Application no: **3/2021/0916**

Address: **2 Rose Cottages Longsight Road Clayton le Dale BB1 9EX**

Proposal: **Rear extension with balcony above, conversion of garage and new fence on existing wall.**

The Local Highway Authority have viewed the plans and highway related documents and have the following comments to make:

Proposed Site Plan 1:100

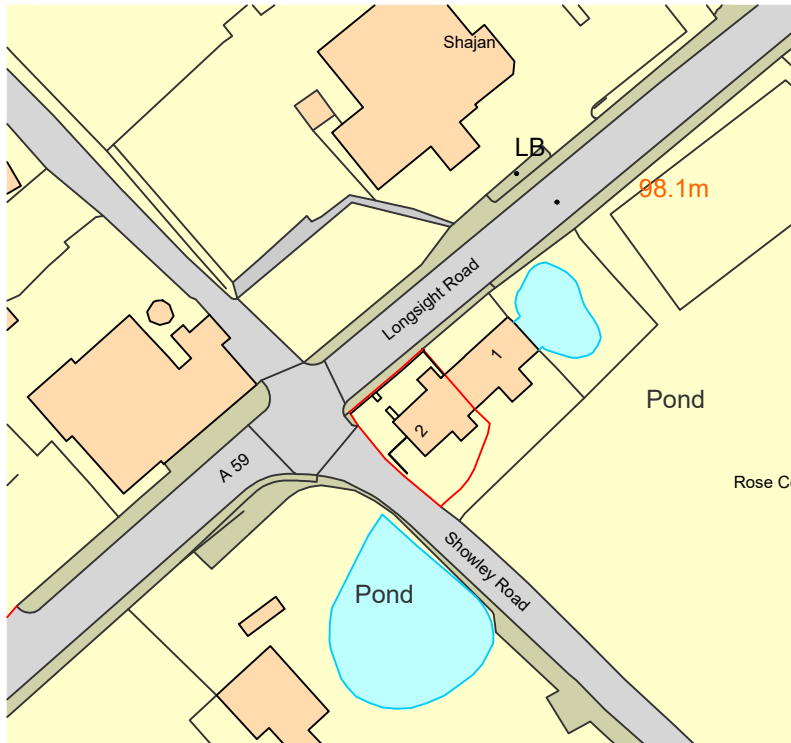
The LHA have reviewed the drawing provided by Entwistle Design Services titled "Site Plans" and understands that the access adjacent to the junction between Showley Road and Longsight Road will be slightly altered. This is to erect a gate at the access.

The LHA have reviewed the drawing and are satisfied that the gate is setback the required distance from the public highway and so the LHA have no objection to the erection of the gate.

Given the location of both accesses which are close to the junction between Showley Road and Longsight Road, with Longsight Road being an A classified road, the LHA are unable to accept a shortfall in parking at the site.

Therefore, while there appears to be space for 2 vehicles at the secondary access adjacent to the existing garage, the LHA are concerned that the rear extension will cause another vehicle space to be lost.

As a result, the LHA require a parking plan of the site which shows that 3 car parking spaces can be provided at the site. This way should a drawing show that 3 spaces are provided, the LHA will formalise the parking area and condition that it is permanently maintained.
